**Application: SSI 7485**

I write regarding the proposed modification to M4-M5 Link, Mod 2 The Crescent overpass and changes to pedestrian infrastructure in North Annandale, Rozelle and Rozelle Bay Foreshore area.

**Figure 4 | Proposed modification** (Source: Design Amendment Report)

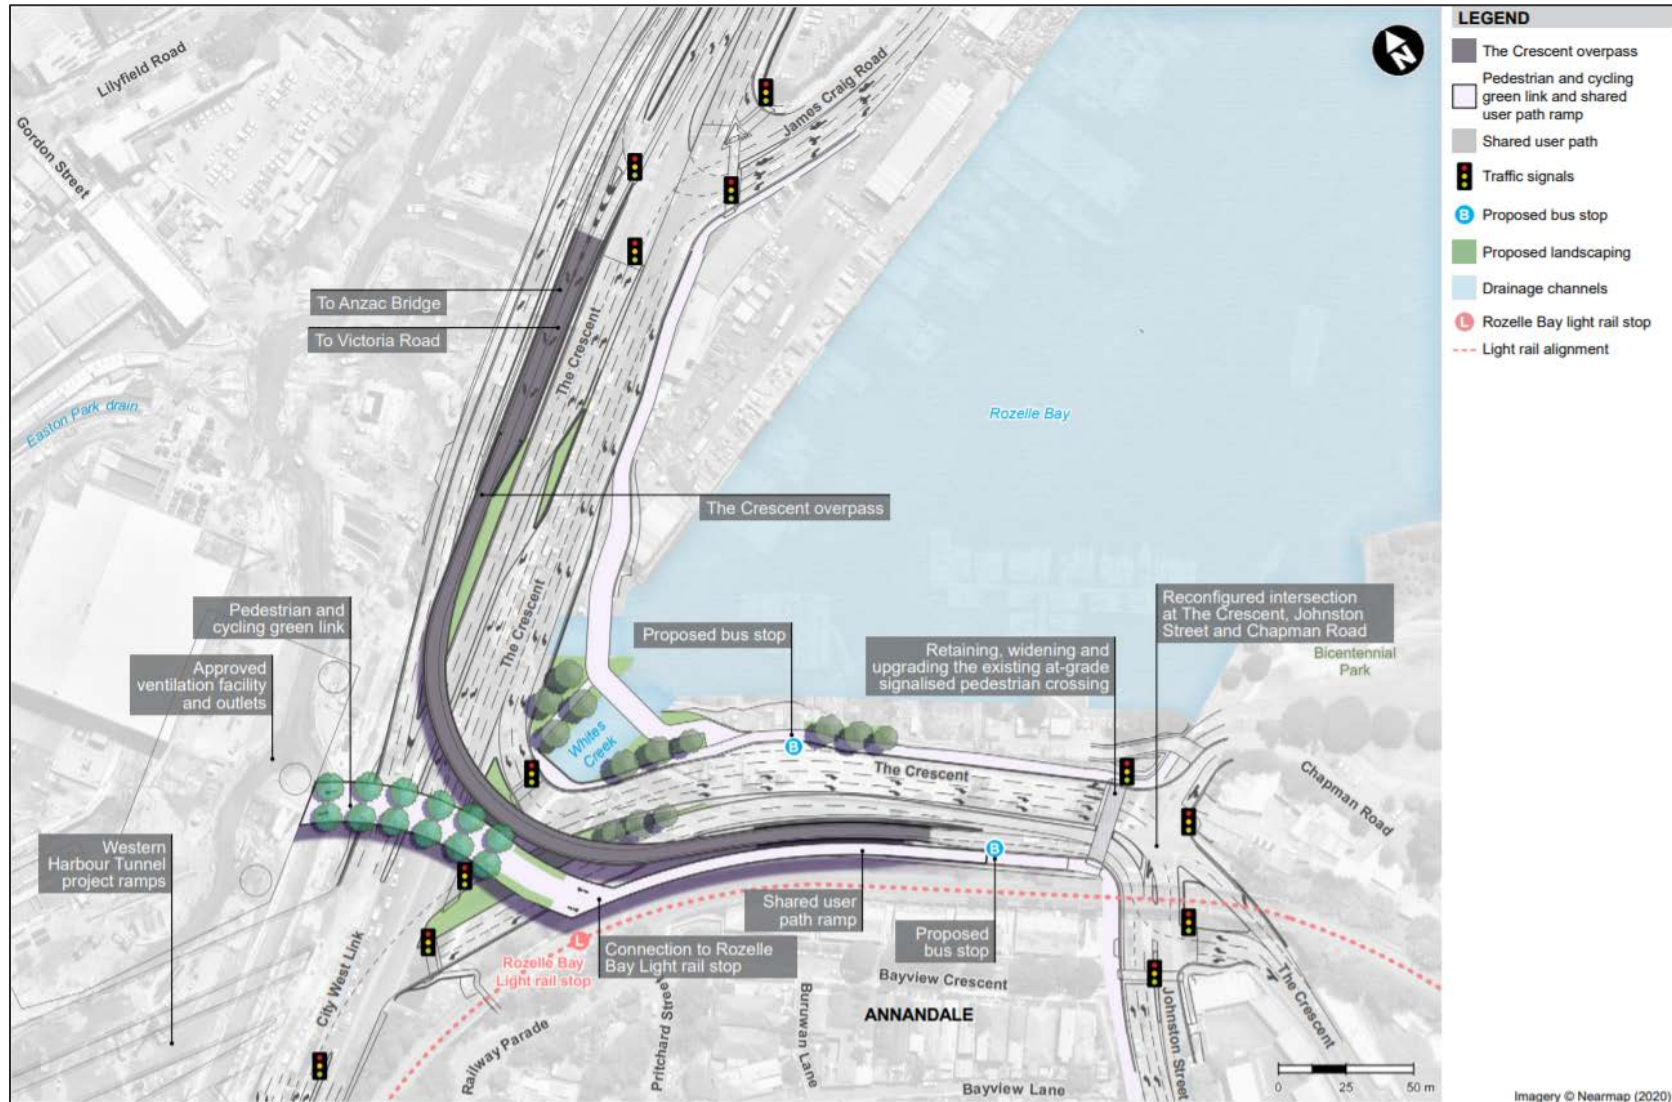
I request RMS work with the community to explore alternate design options to the proposed new car overpass design and the changed pedestrian and cyclist links. I am seeking the reinstatement of the safe, direct access from the approved EIS GreenLink to create a continuous green open space connection from the Rozelle Rail yards and Annandale to the foreshore. The GreenLink was more than just a walk way - it put people central to the design, maximising safety, and providing much needed accessible open space for the community now and into the future Bays Precinct design.

- The significantly reduced safety and increased risk for pedestrians and cyclists with removed access over The Crescent to Bicentennial Park and the increased traffic along Johnson Street.
- Being required to cross five sets of pedestrian lights at The Crescent as my option to reach the foreshore from Annandale or from Rozelle Bay light rail stop.
- Removal of direct active links to the foreshore, cutting the community off from the area and the proposed revitalisation of the entire Bays Precinct, including linking the Light Rail and Bus stops to a Ferry wharf and Metro station.
- Urban and landscape design that is being built before a finalised Masterplan for the area.
- Traffic changes that limit movements around the suburb and create further congestion in the local streets of Annandale, Forest Lodge, Glebe, Lilyfield and Rozelle with no planning to deal with these.

- Reinststate the GreenLink connecting communities and green open space from Rozelle to Bicentennial Park
- Relocate and design pedestrian and cyclist connections that are continuous, safe and direct.
- Design the modification infrastructure and active links in response to the character of the suburbs, the location of the foreshore and it's potential future development.
- Provide pedestrian and cyclist paths that maximise people safety and do not force them onto busier streets, unsafe concrete plazas and caged walkways.
- Integrate active and direct connections to all active transport - including the future Metro West and Foreshore Ferry Wharf

PLEASE REINSTATE APPROVED  
DESIGN

**Figure 10 |** Indicative pedestrian and cyclists crossing over The Crescent and Johnston Street  
(Source: Response to submissions on Design Amendment Report)

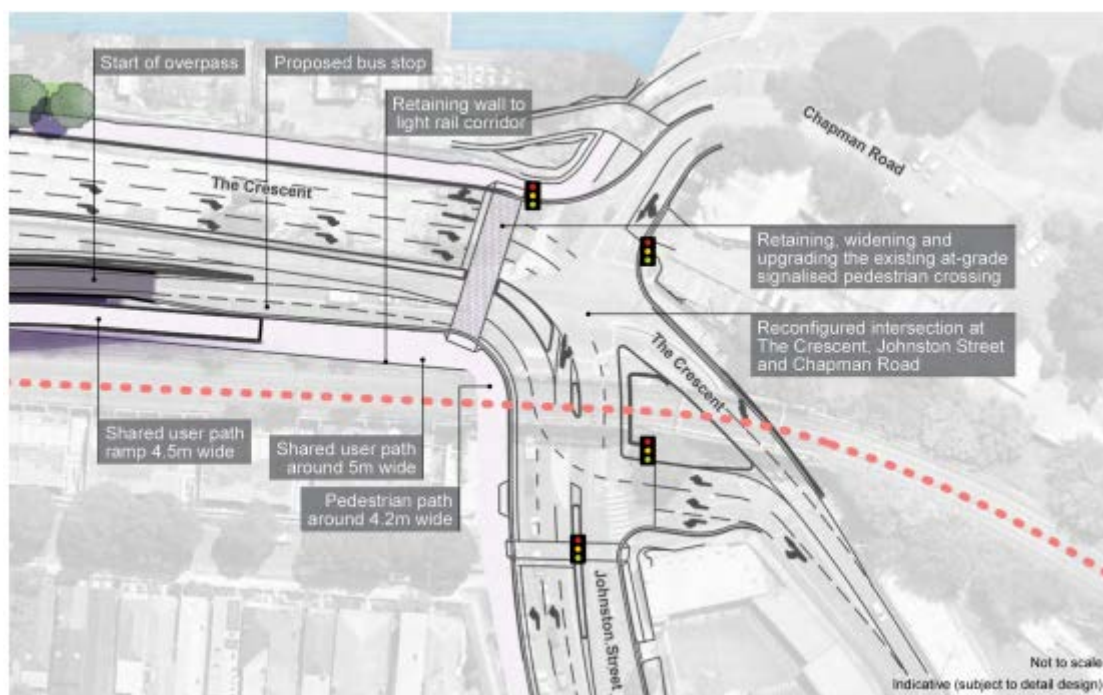
*I am a keen cyclist and I like many others use this intersection on route to the city. These modifications totally disregard cyclists and pedestrians to the Glebe parkland.*
